**Subject: Environmental Impact Statement – Mamre Road Data Centre Campus
(SSD - 92743706) (Penrith)**

CPHR comments on the Environmental Impact Statement – Mamre Road Data Centre Campus (SSD-92743706)

Project name: MAMRE ROAD DATA CENTRE CAMPUS
Drawing title: SEDIMENT AND EROSION CONTROL PLAN SHEET 4
Drawing Number: SYD4-SITE-DRG-ATL-CIV-02204
Rev: 01

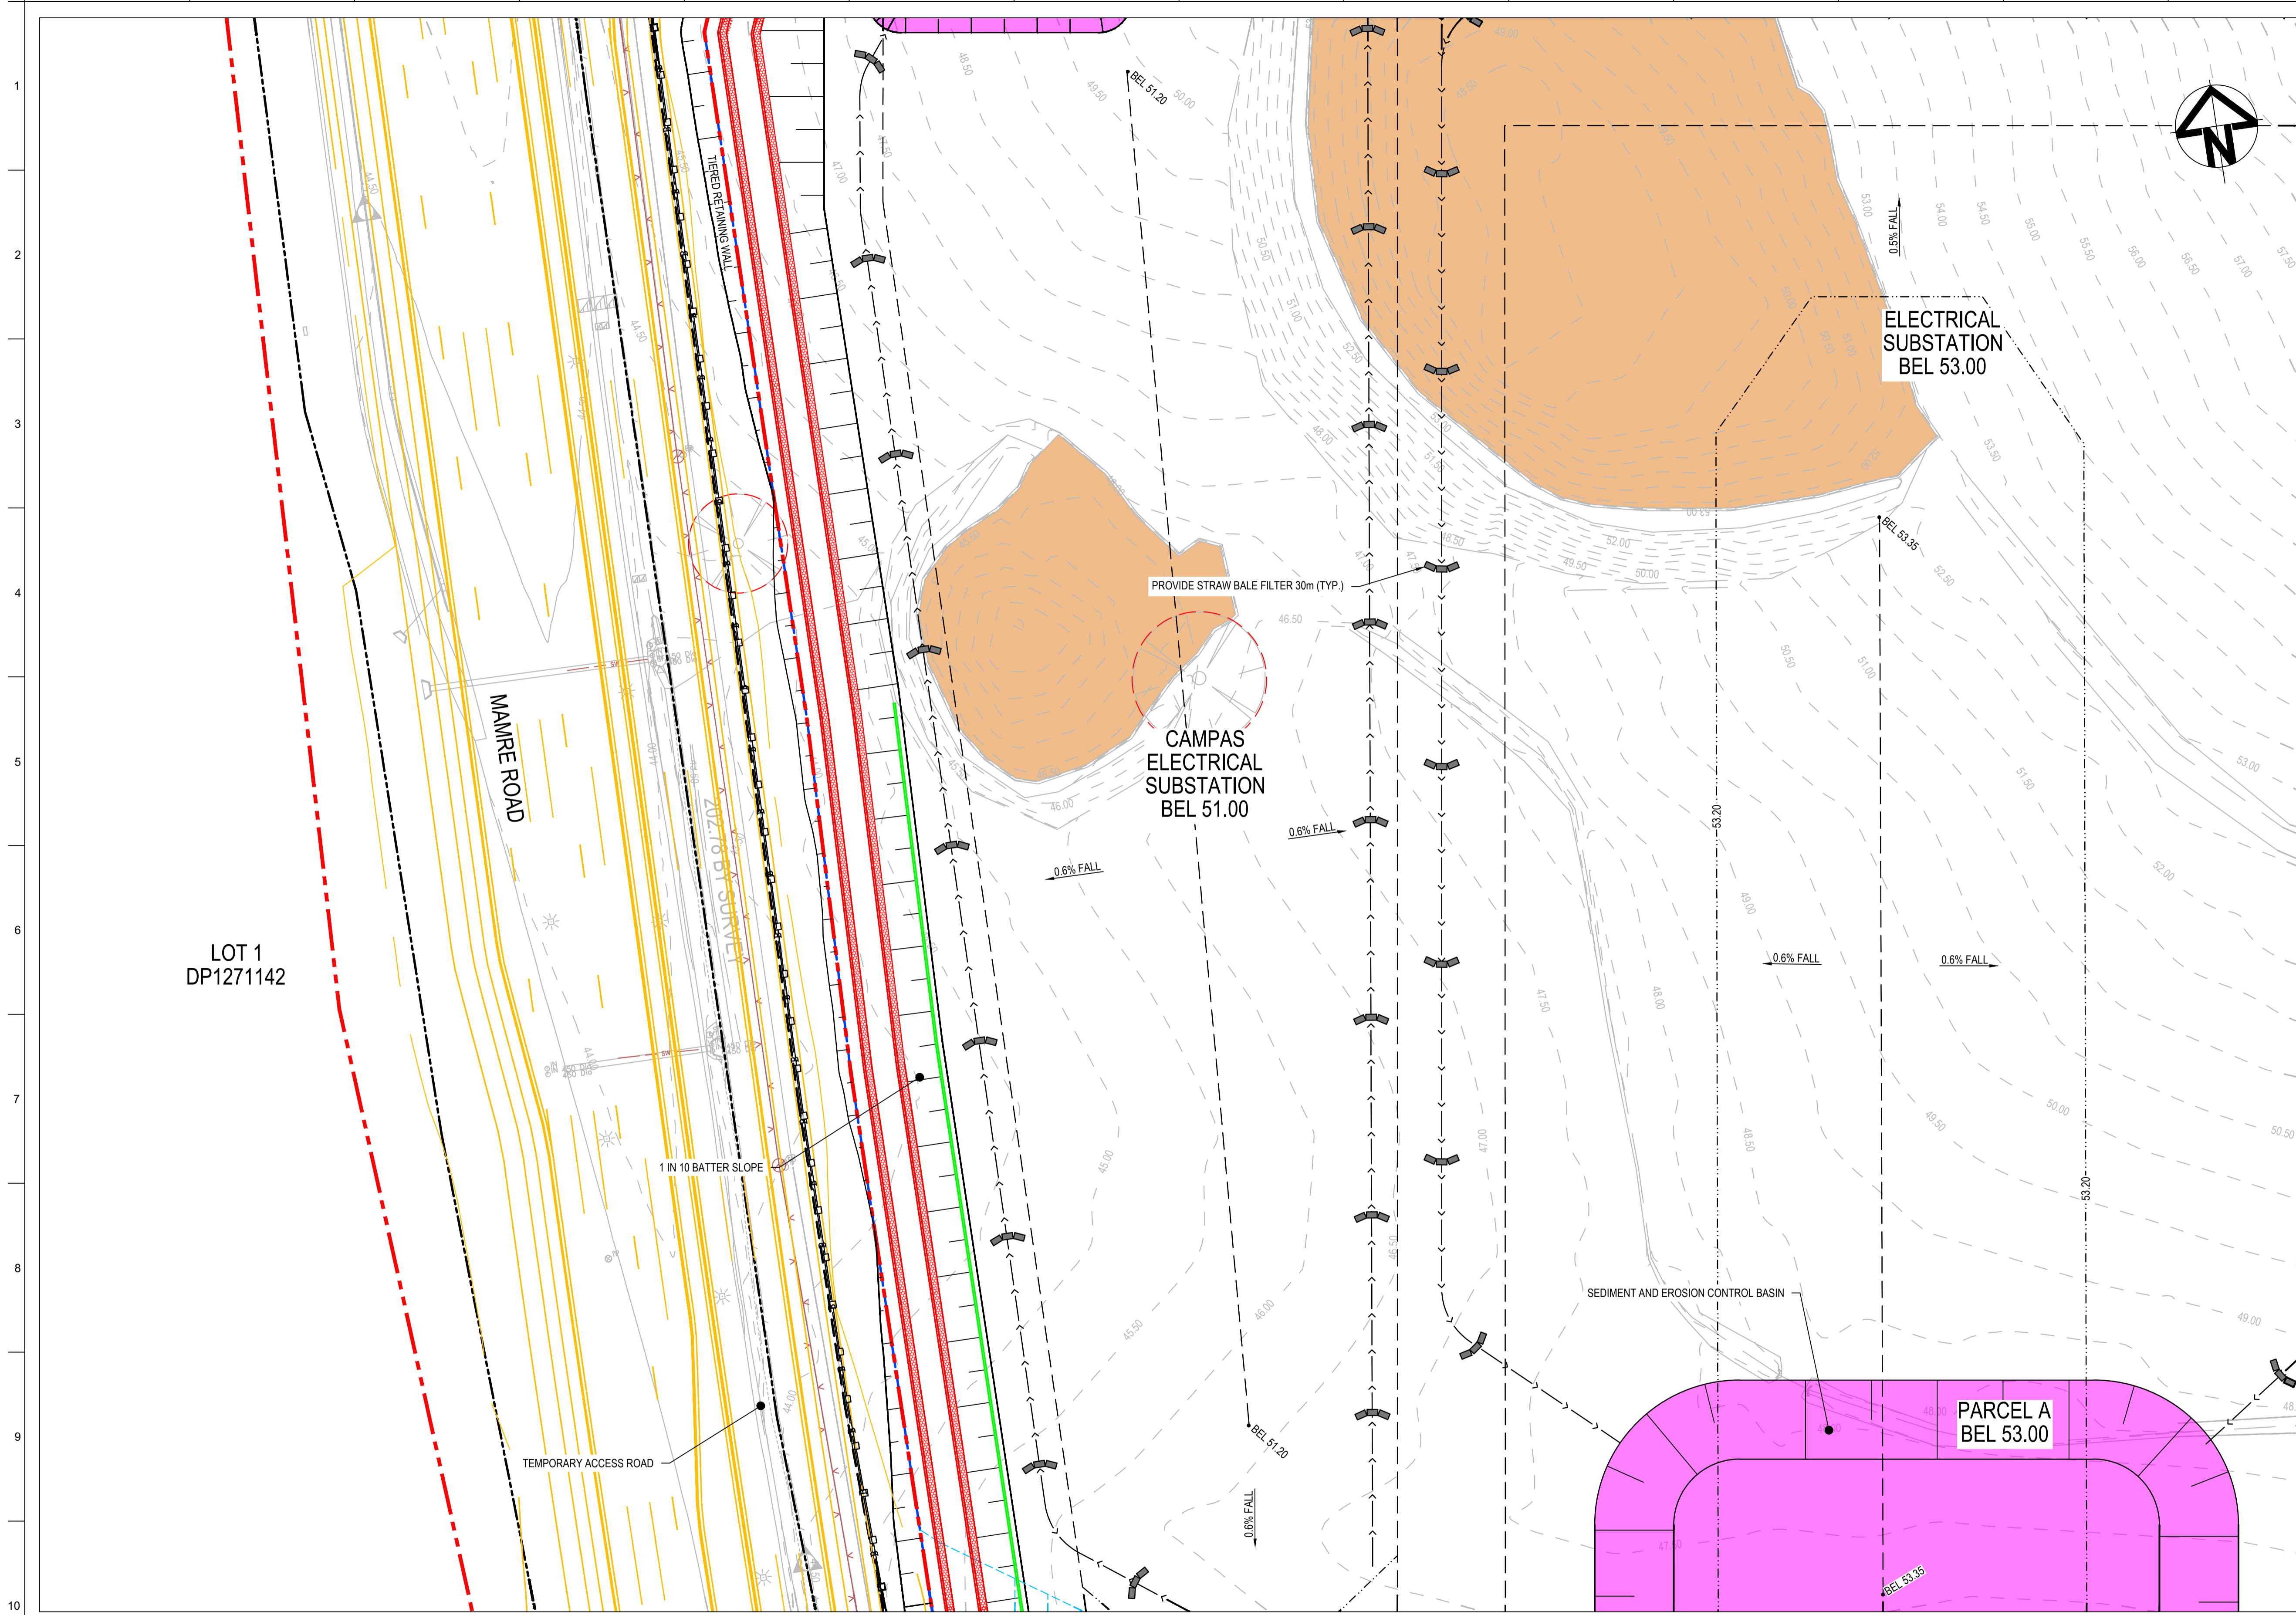
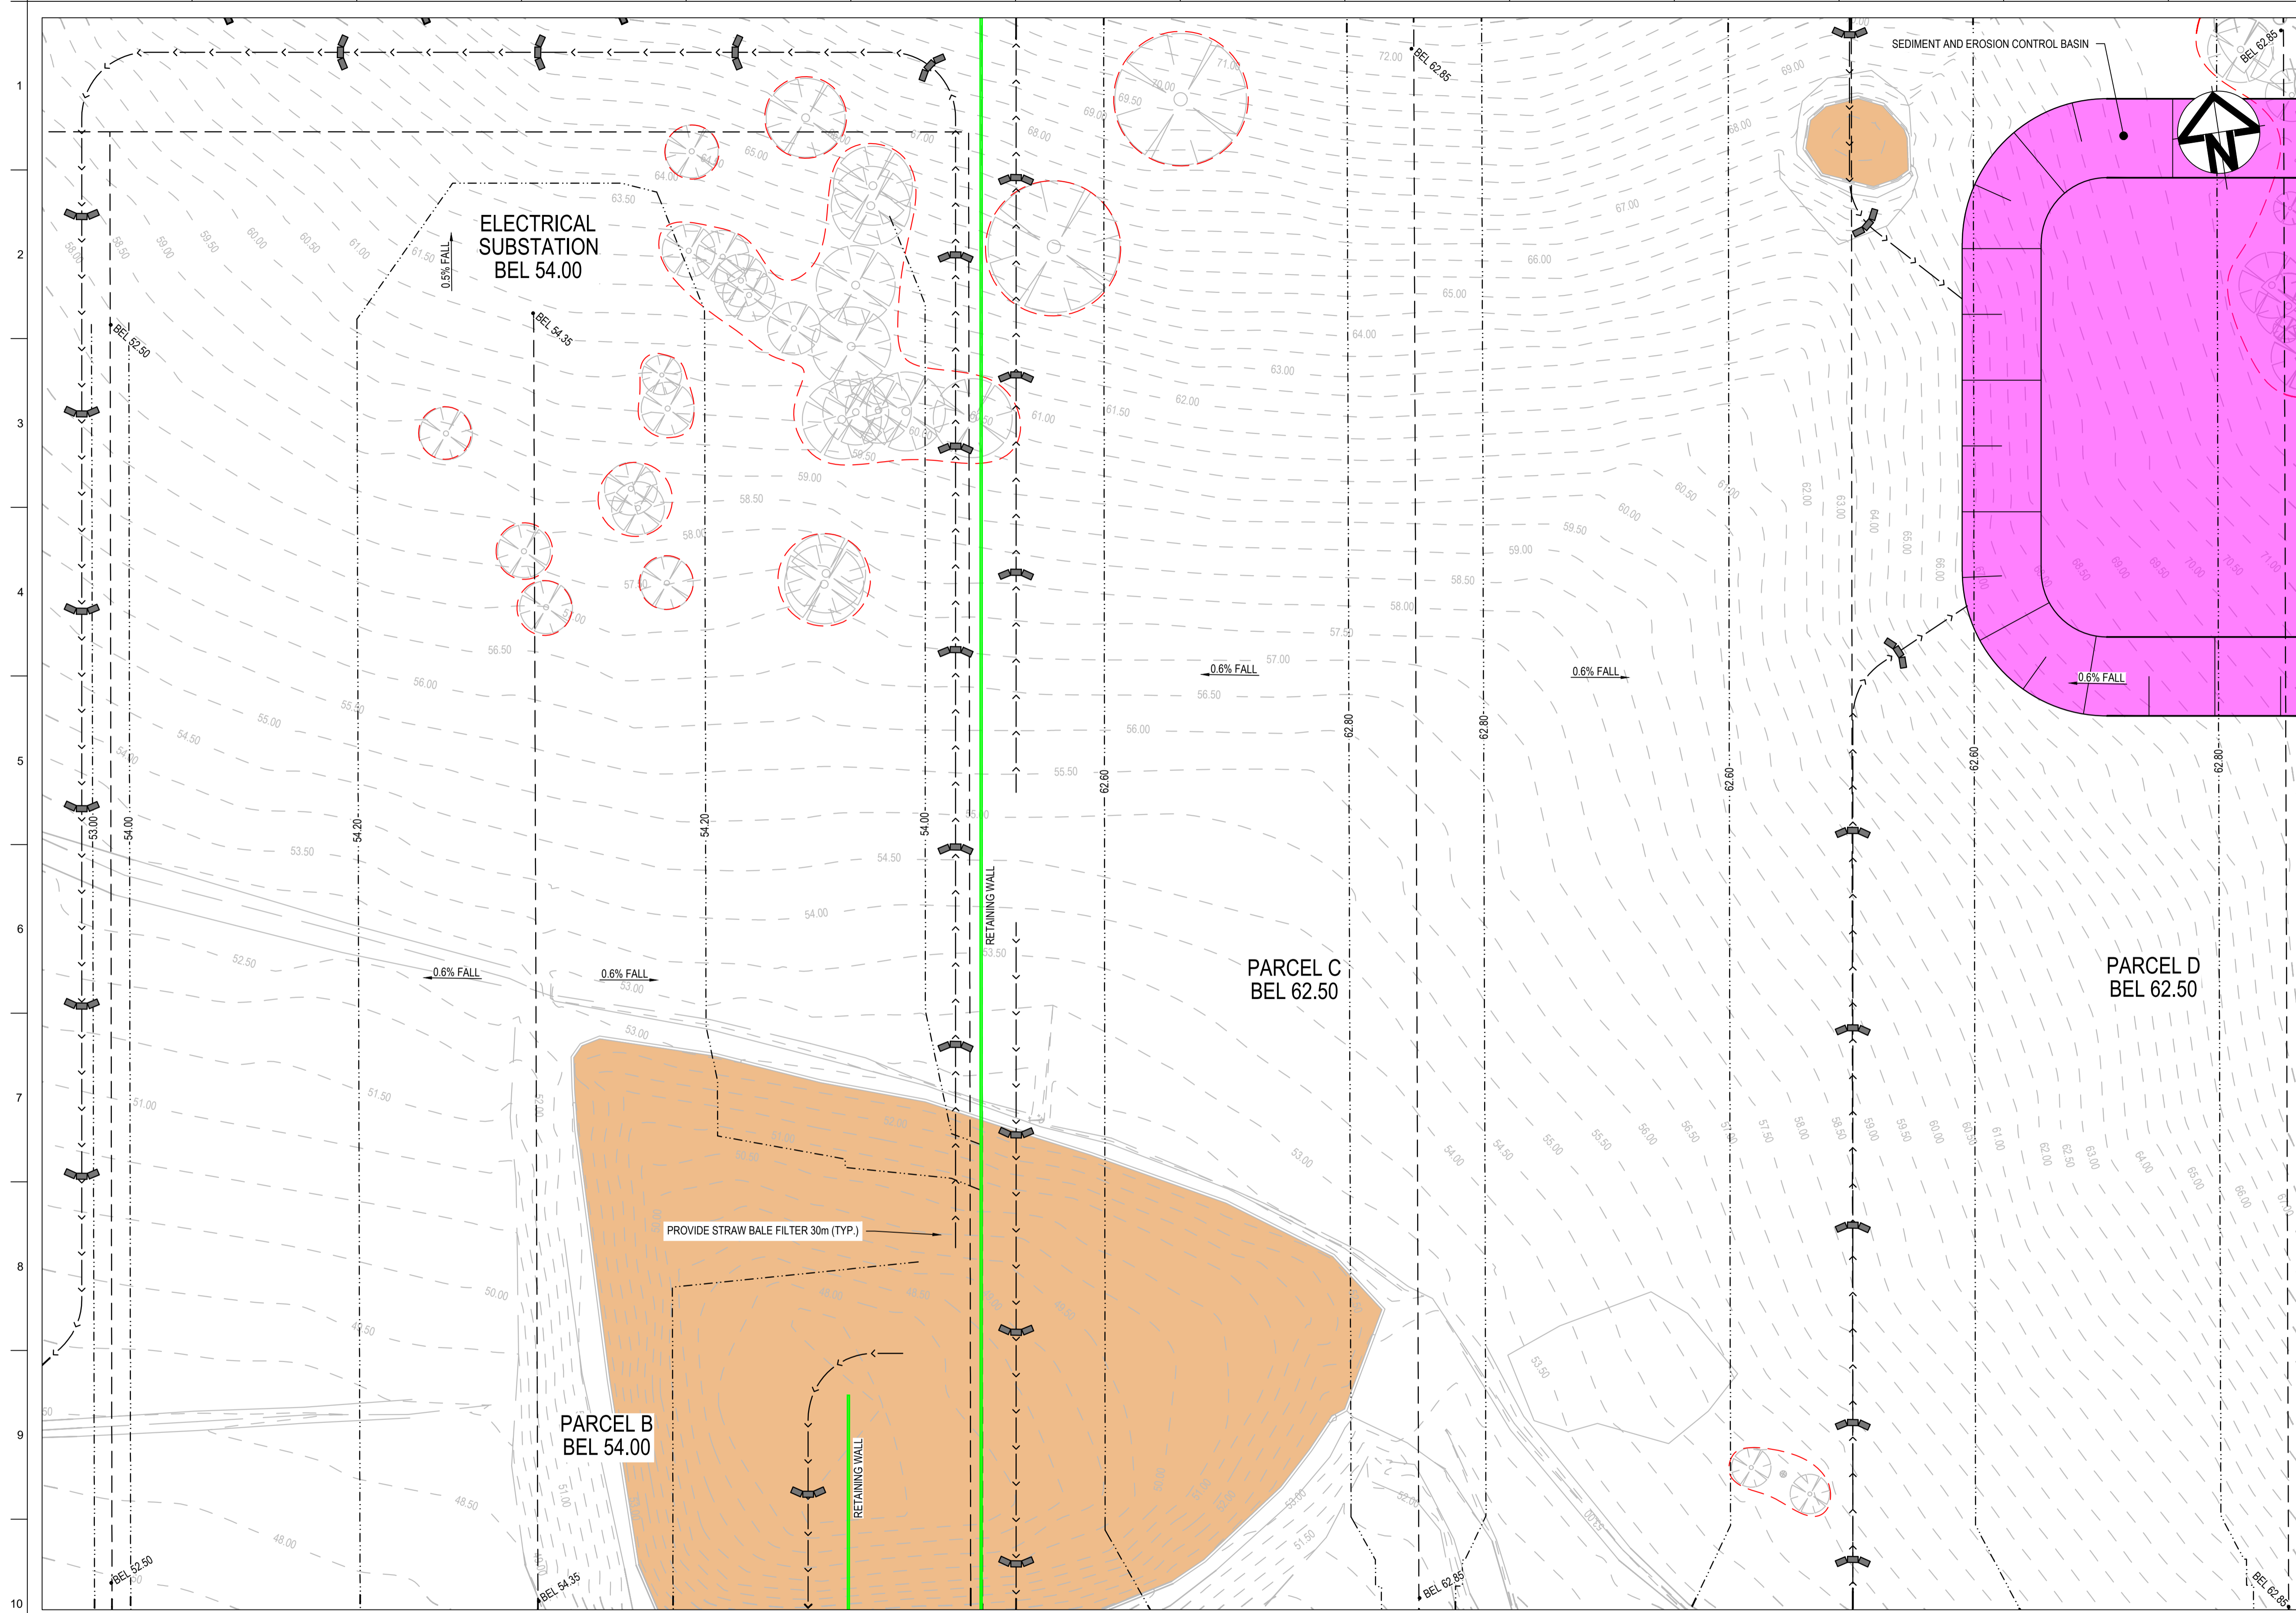
11.	<i>Erosion and Sediment Control Plan (ESCP)</i>	CPHR advises that the ESCP has inadequate details for each construction phase to understand the proposed stormwater strategy. The proposed erosion and sediment control details for all interim phases was also not provided or included in Civil Drawings. For each construction phase a civil drawing with the proposed ESCP measures should be provided. CPHR advises the applicant refer to 805 Mamre Road (SSD-30871587) ESCP as a good example.

Recommended actions: • To demonstrate the construction phase stormwater quality targets are met, a detailed ESCP must: ○ be developed and certified by a Certified Professional in Erosion and Sediment Control, or a qualified and experienced civil engineer with at least 5 years' experience in the development of site-specific soil and water management plans ○ be prepared in accordance with the Blue Book (NSW Government 2004) and water sensitive urban design (WSUD) considerations set out in Chapter 3 of the Technical Guide ○ provide conceptual designs that include the site, catchment and key features of erosion and sediment controls on scaled drawings ○ illustrate appropriate controls, that when implemented will achieve the construction phase stormwater quality targets in Table 2 of the Technical Guide. • As the subject land is larger than 2,500m², the Technical Guide provides best practice initiatives which strengthens requirements from the Blue Book. This involves designing and implementing sediment controls that treat at least 80% of the average annual runoff volume (i.e. 80% hydrological effectiveness) to 50 mg/L total suspended solids (TSS) or less, and pH in the range 6.5–8.5. To achieve these construction phase targets, the design of the basins generally needs to: ○ be sized and operated in accordance with either a Type-A or Type-B sediment basin as documented in <i>Best Practice Erosion and Sediment Control</i> (International Erosion Control Association (IECA), 2008) ○ be provided with an automated system of flocculant dosing and a suitable supply of flocculant/coagulant, with the type of flocculant/coagulant determined based on the <i>Chemical coagulants and flocculants fact sheet</i> (IECA 2018) ○ have markers within each basin to show the maximum sediment storage level and any additional water storage capacity for water reuse ○ limit discharge from the primary outlet system to 50 mg/L TSS, with a pH within the range of 6.5–8.5 ○ be operational before any disturbance occurs in the catchment upslope of the basin ○ if not using Type-A or Type-B sediment basins provide robust justification to demonstrate use of alternatives.
